4 July 2018

**Lismore Base Hospital Redevelopment Stage 3C, 60 Uralba Street Lismore (SSD 8963)
Notice of Exhibition**

Mr R Mallam
Snr Development Assessment Officer (Planning)

NORTH TOWER LEVEL 7 - Internal Fitout Zone

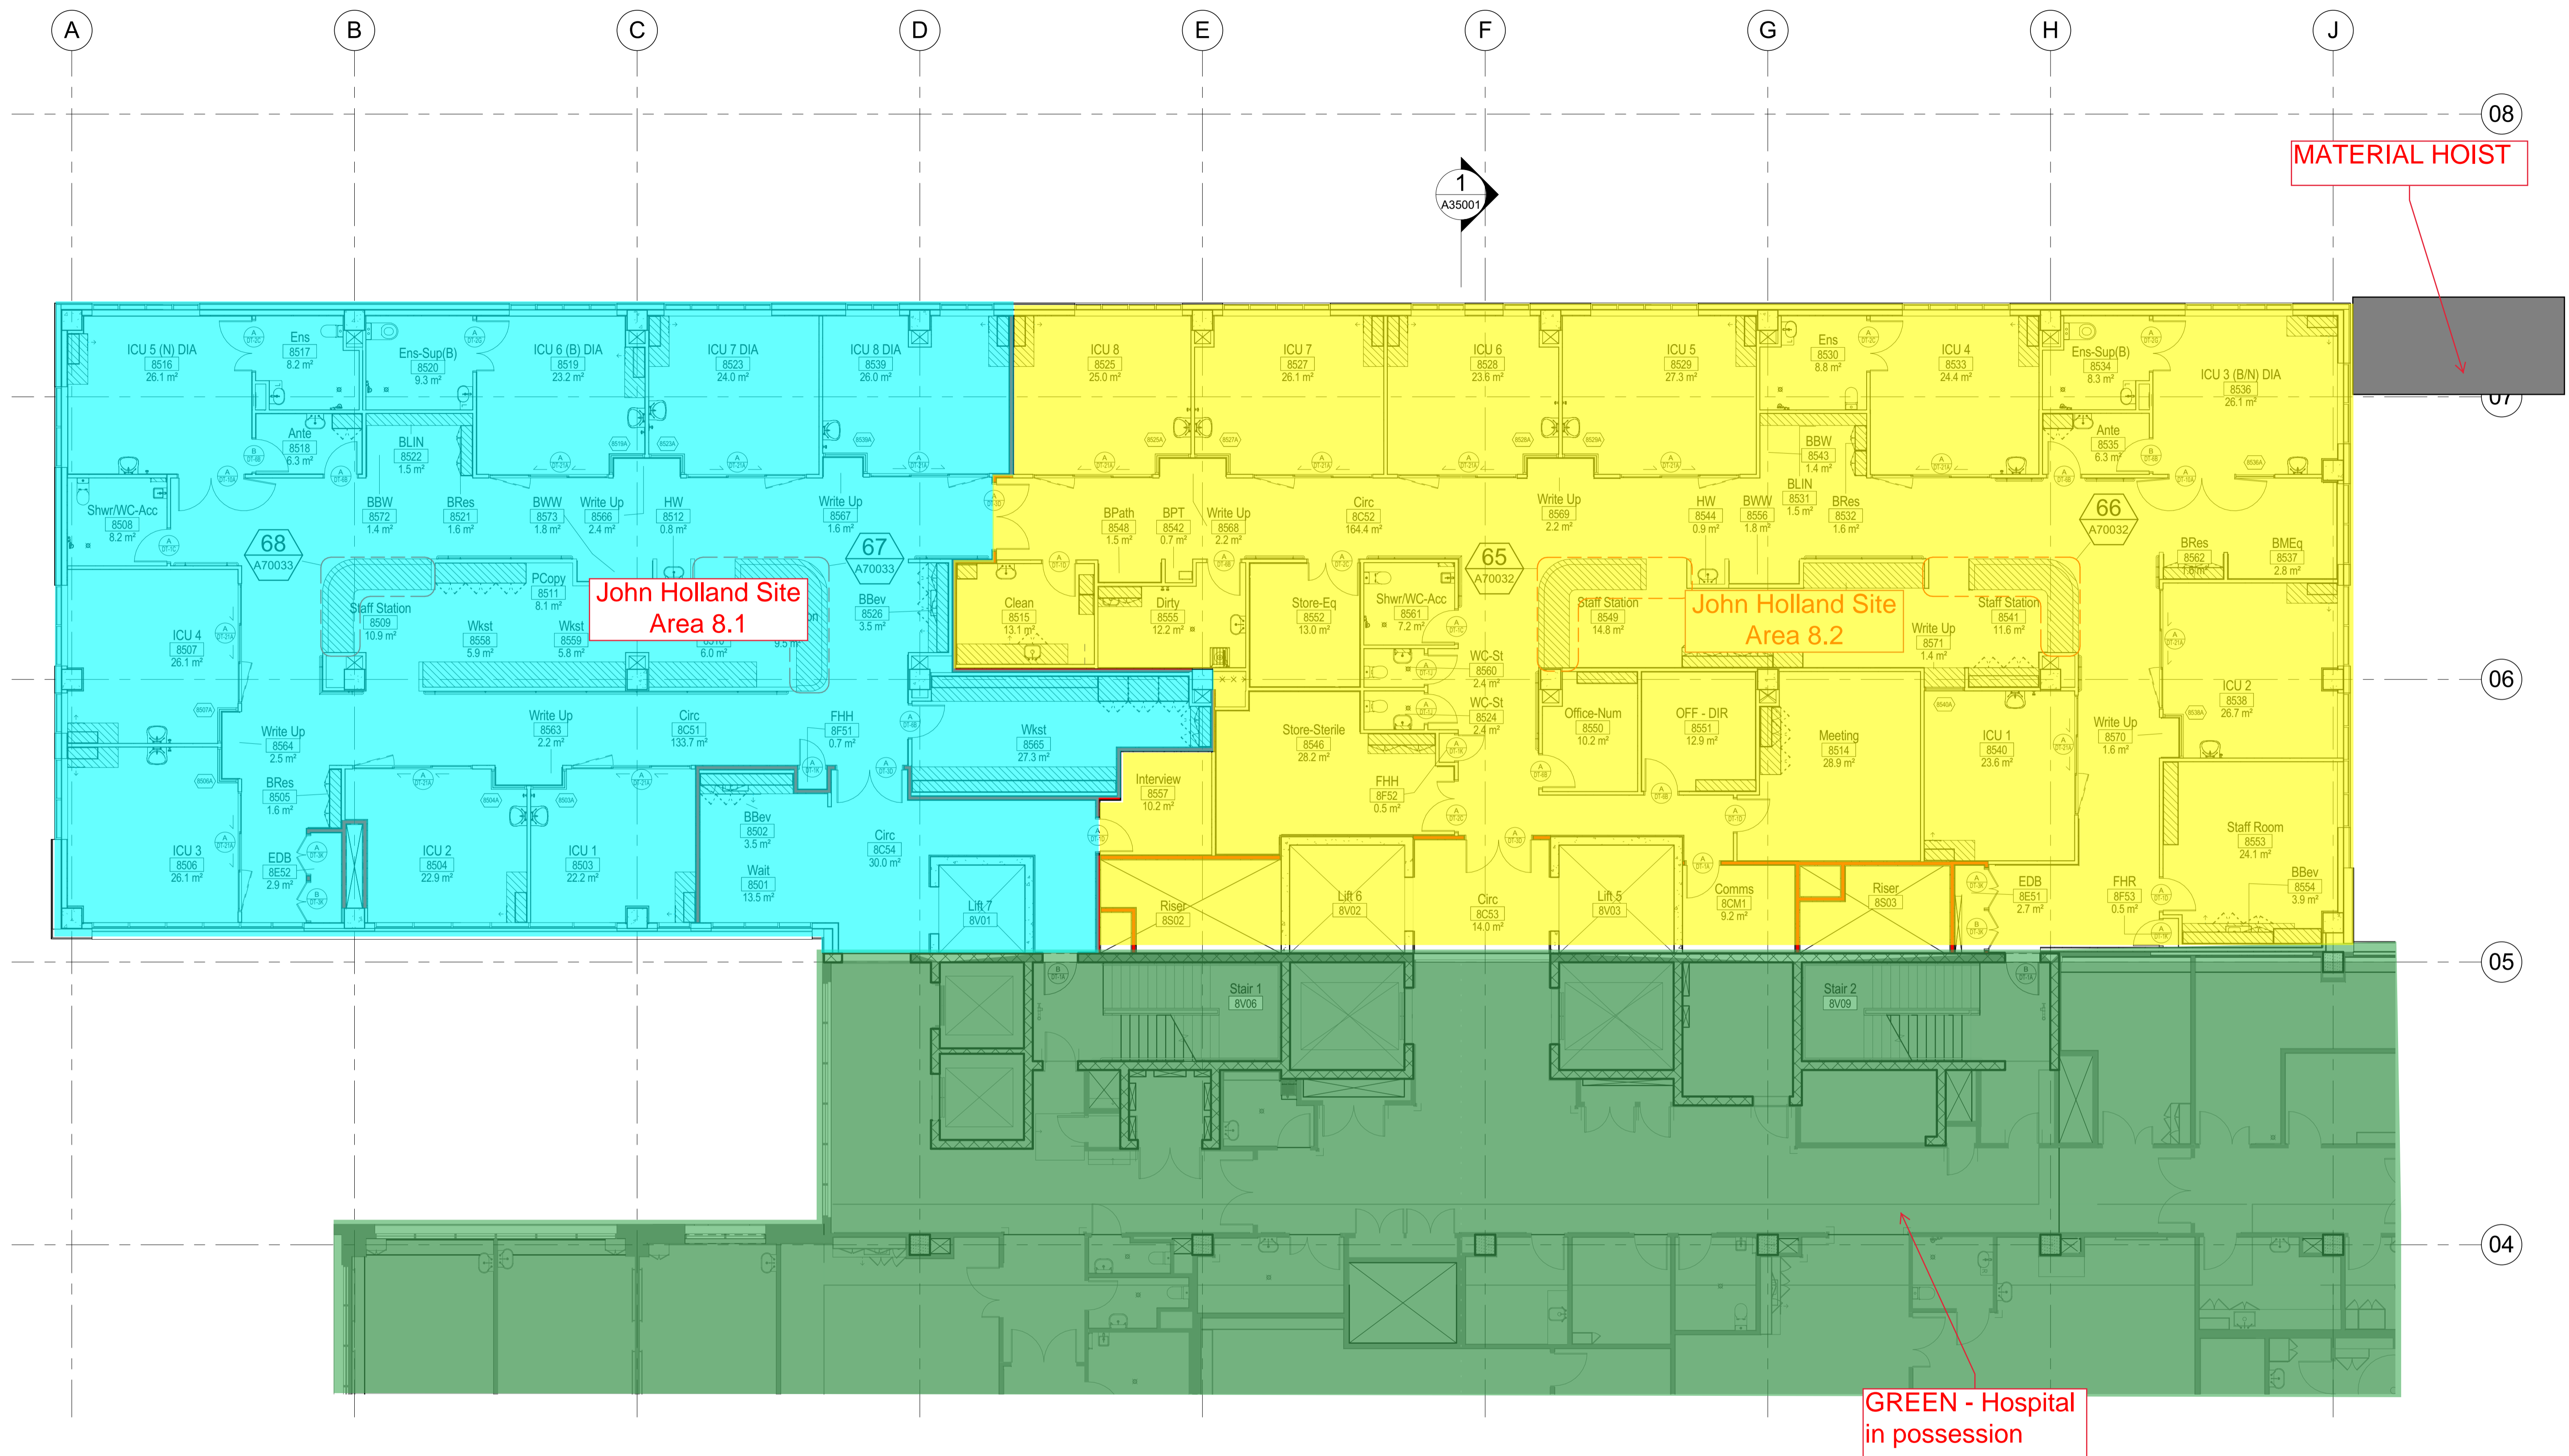
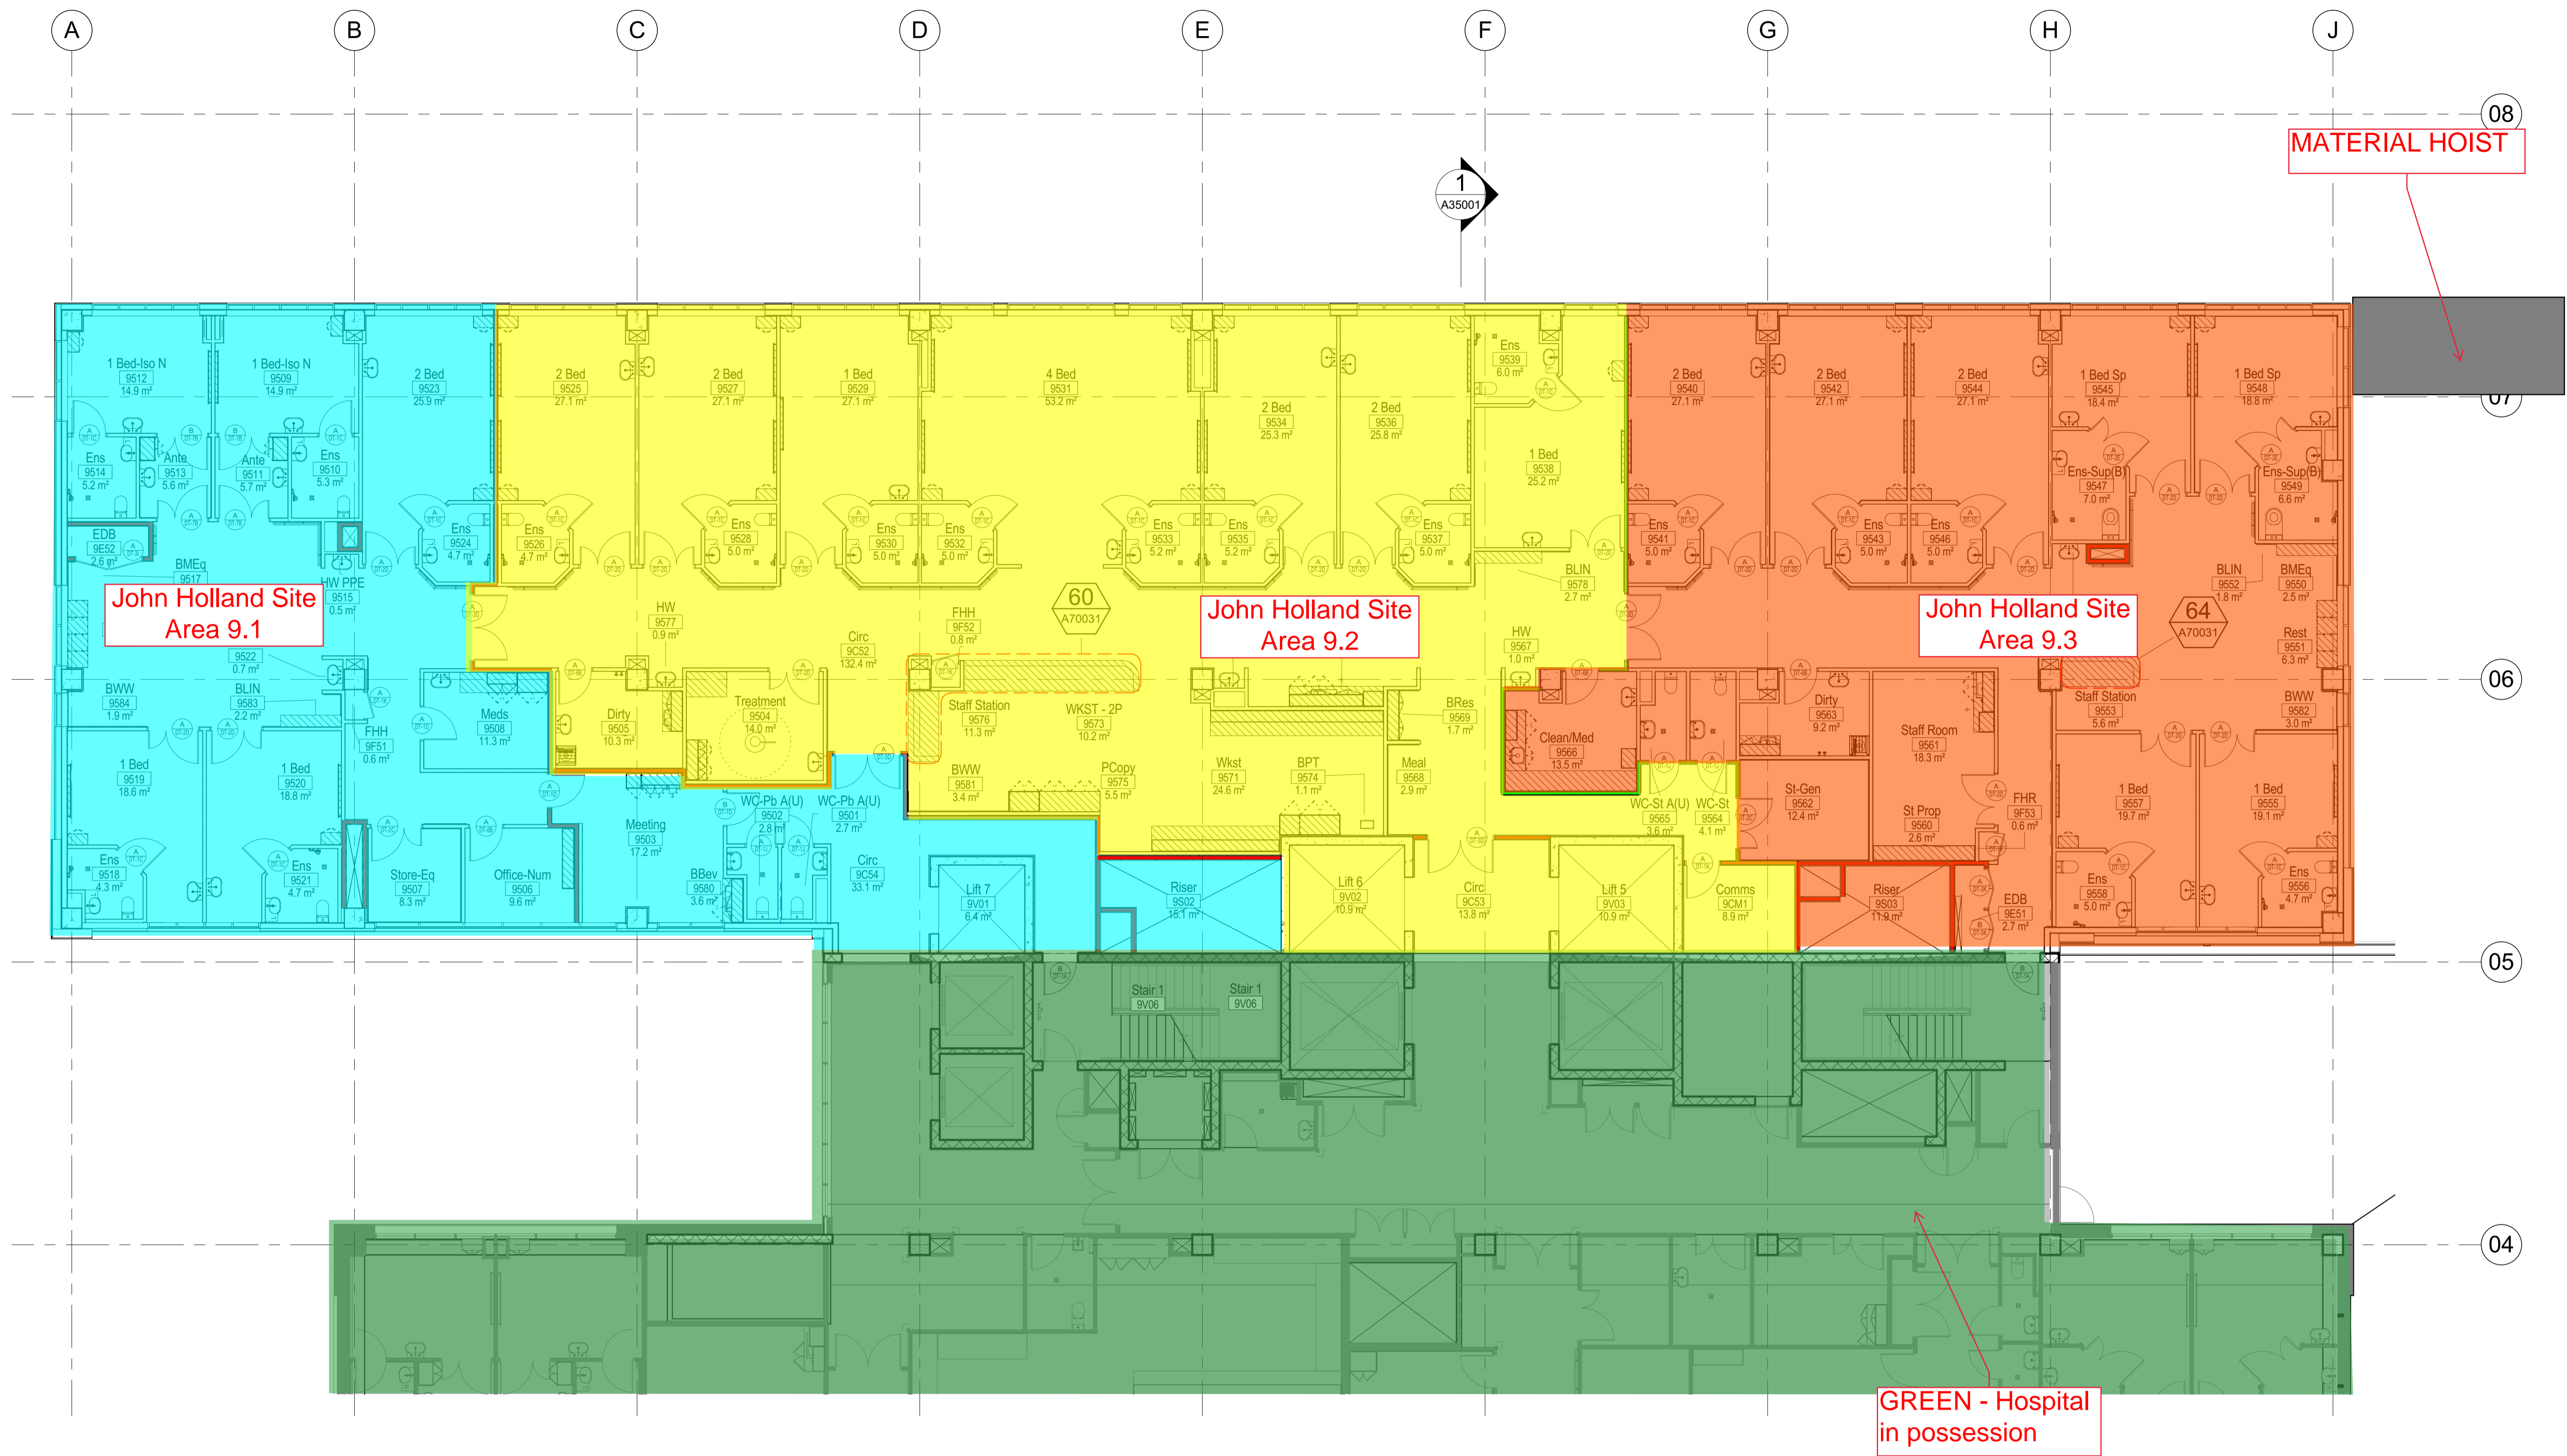
- seek information from the applicant as to the proposed use of Level 5 (Block B/C) and Level 7 (Block A/C) that are no longer required for beds; and
 - ensure the subject development consent addresses the lawful use of these redundant areas (Level 5 (Block B/C) and Level 7 (Block A/C)) so that they will not be able to be used for purposes concurrently with the NTX (i.e. uses approved under previous consents) that increase traffic generation and parking demands without such issues being properly assessed.

1 Building Elevation - North NTX SSDA
1 : 200

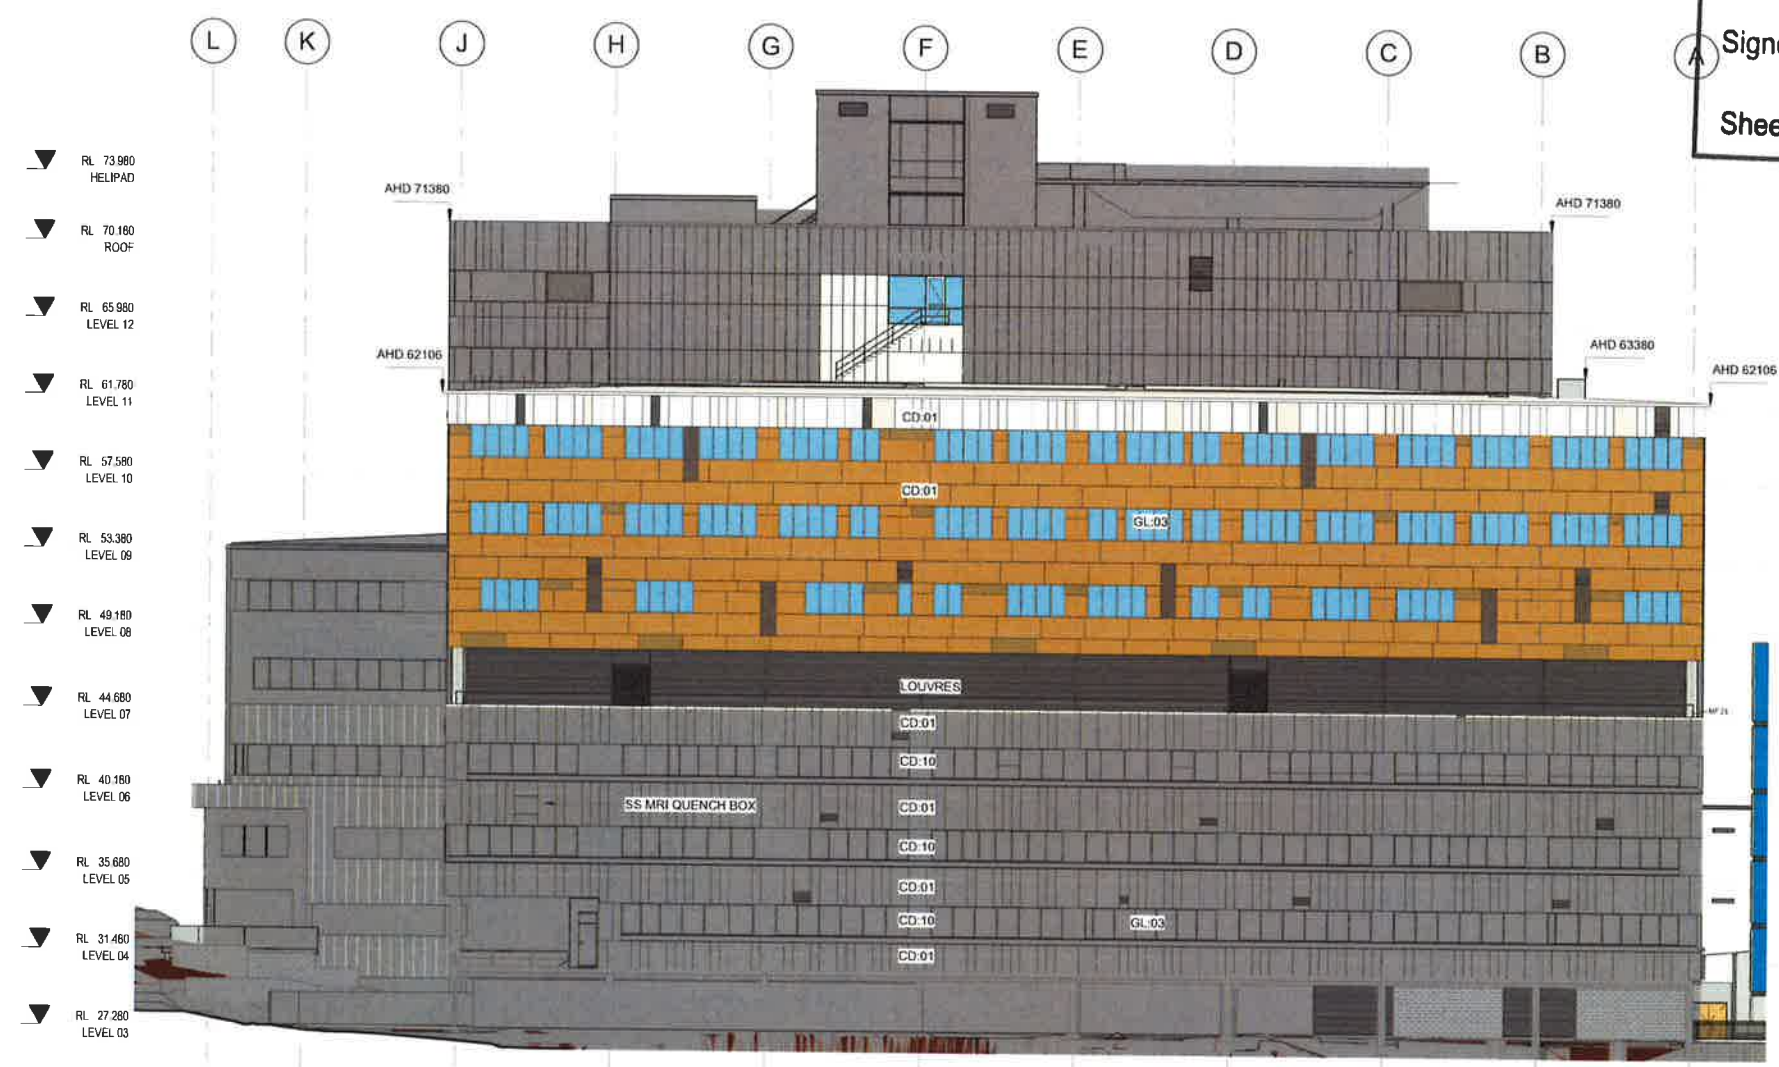
9. **Glare and Reflection** – Council requests that the following condition be applied to any consent:

Roofing and wall cladding materials shall be factory pre-finished with low glare and reflectivity properties. The selected roofing and wall cladding material and colour must not cause a glare nuisance or excessive reflectivity to adjoining or nearby properties, In the event that a glare nuisance does arise from the use of a material, Council reserves the right to require materials to be treated to address the glare nuisance.
